Rezoning Transportation Analysis

Petition Number: 2020-178

General Location Identifier: Tax ID 08108503

Date	Description
12-28-20	First Review (WB)

RZ-1.0

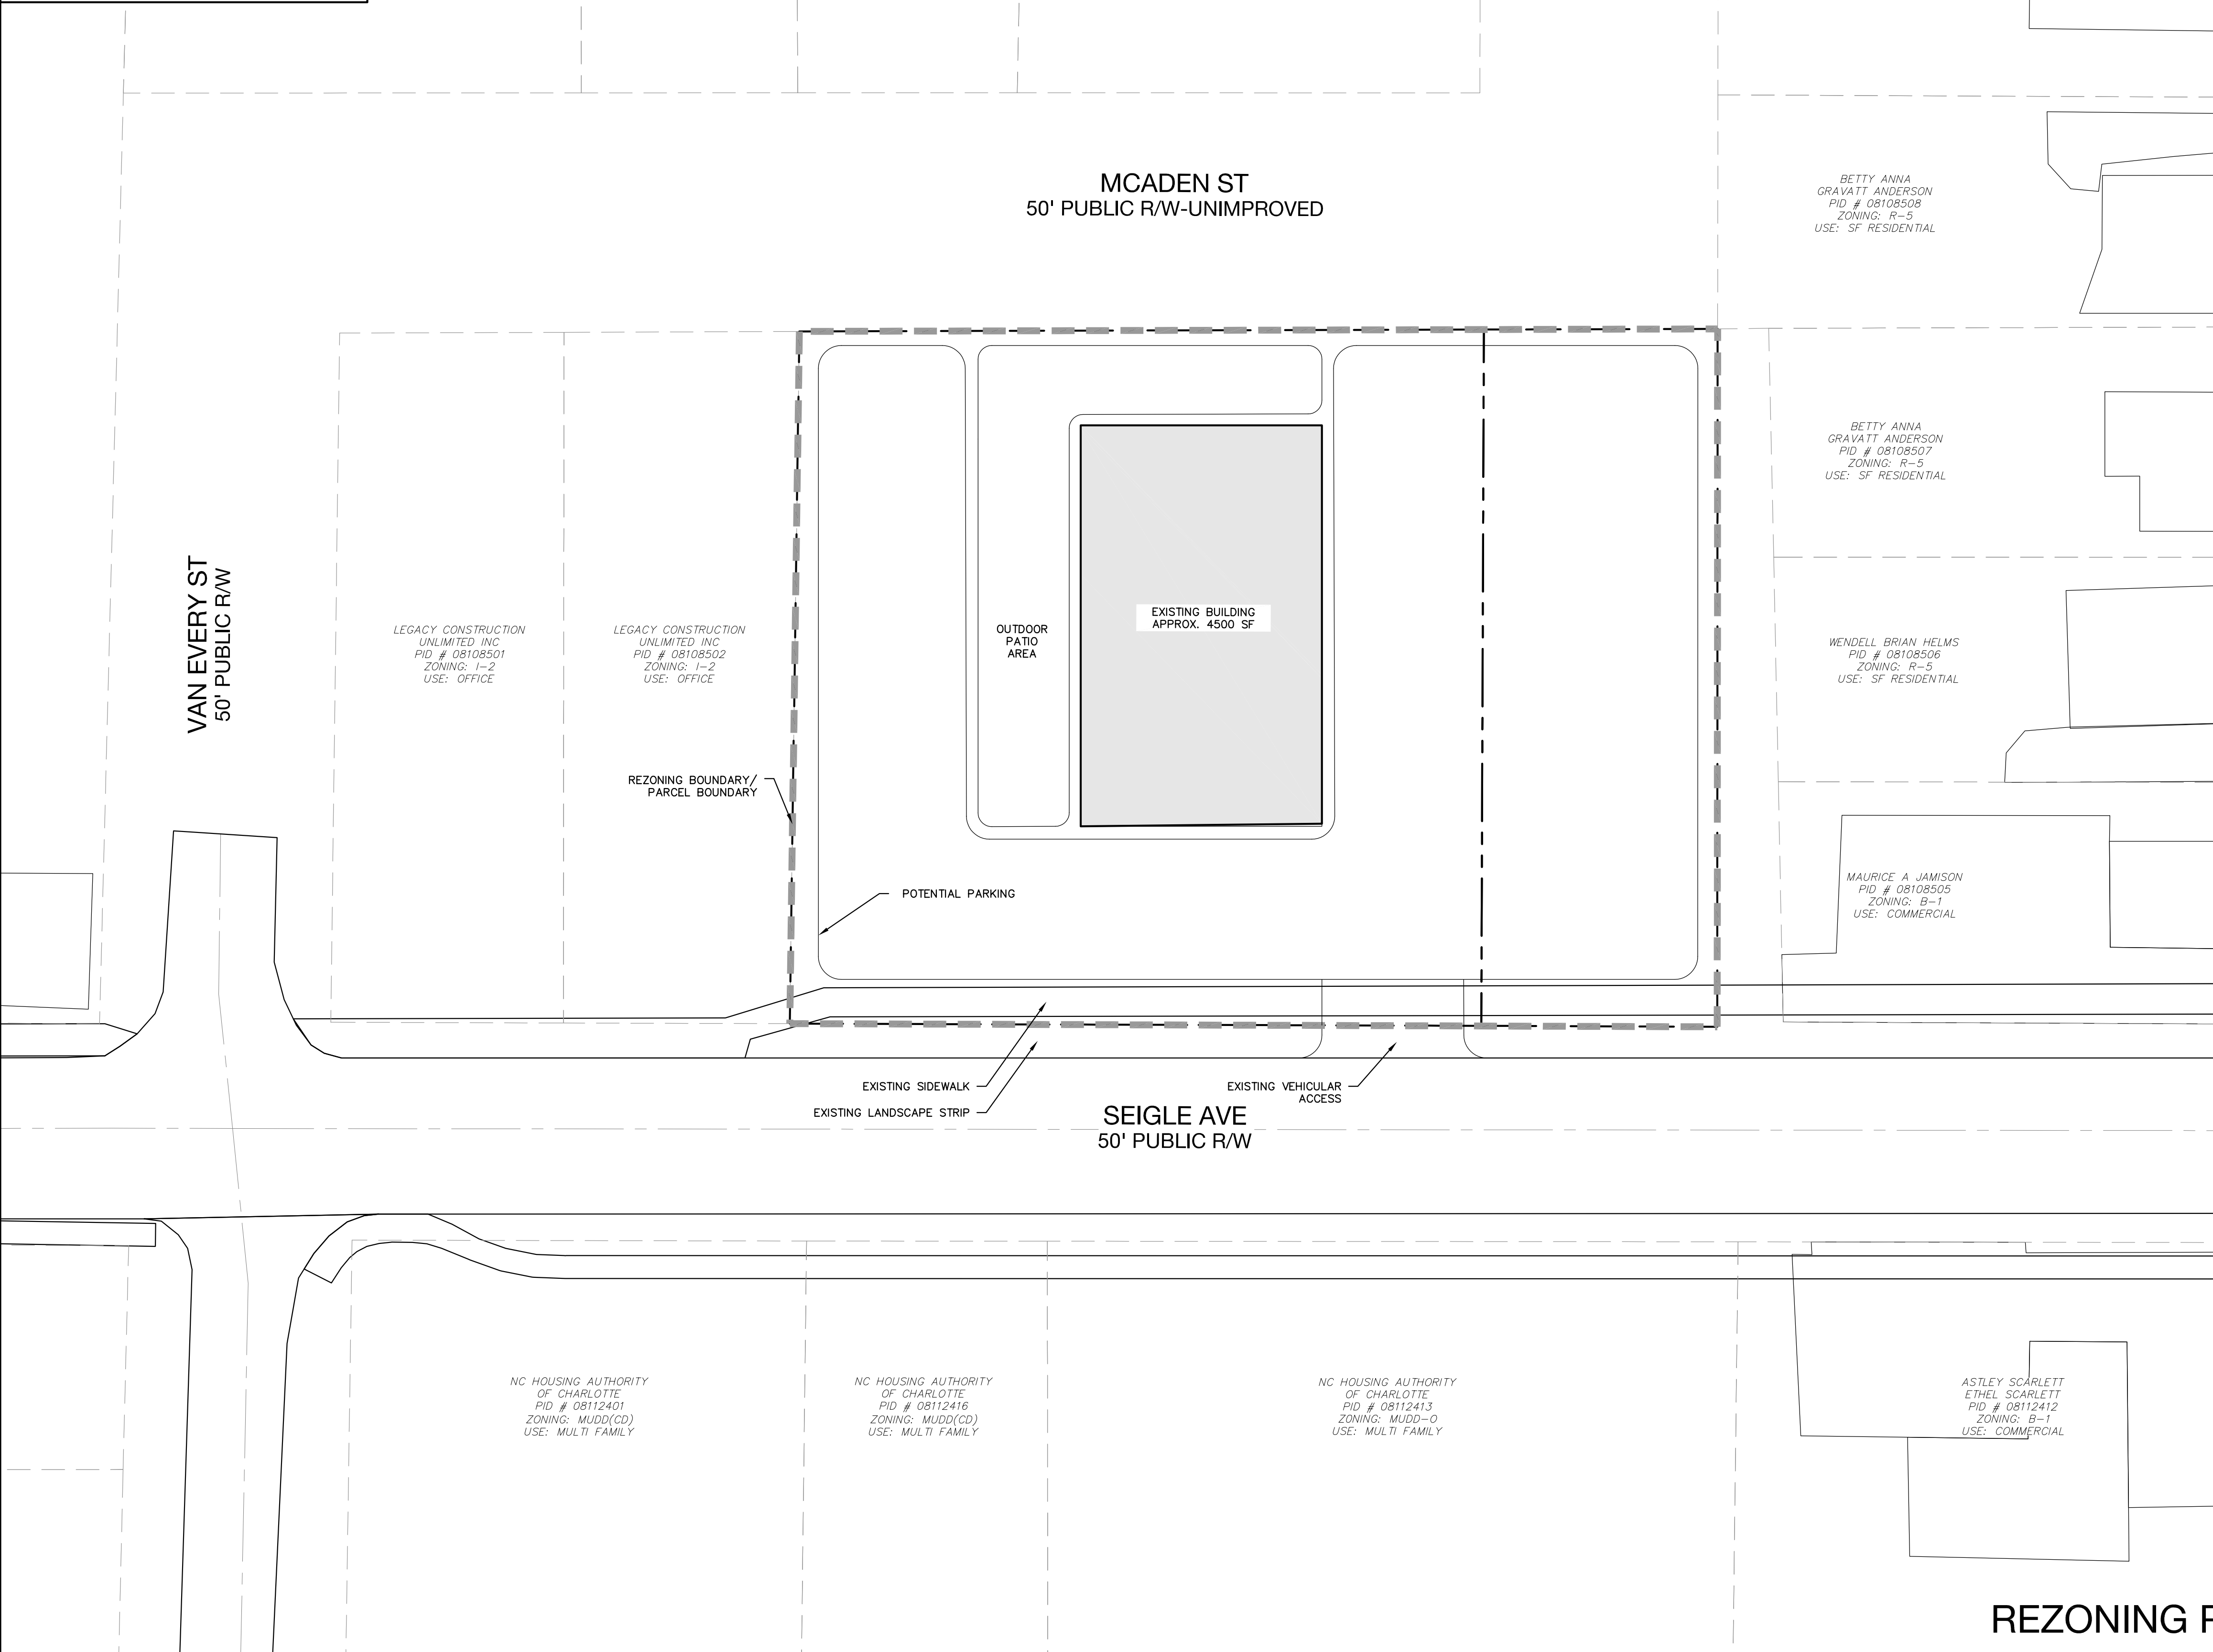
1. **Curbline:** The proposed zoning district has a setback measured from back of the existing or proposed future curbline.
 - a. **Seigle Avenue:** The future location of curb and gutter is in its existing location.

Label and dimension the curb and gutter from the centerline on the site plan.

3. Revise site plan and conditional note(s) to commit to dedicating 30-foot right-of-way from the Seigle Avenue centerline. Label and dimension the right-of-way from the road centerline.

4. Under the site development data shown on the site plan, approximately 25 parking spaces will be required. Per site conditional note Transportation 2, if off-site parking is to be considered as part of this petition, please state the location of where said off-site parking spaces would be provided. If there is a request to use on-street parking spaces, please specify in this conditional note.
5. A site plan note(s) specifying dedication and fee simple conveyance of all rights-of-way to the City before the site's first building certificate of occupancy is issued is needed. CDOT requests rights-of-way set at 2' behind back of sidewalk where feasible.
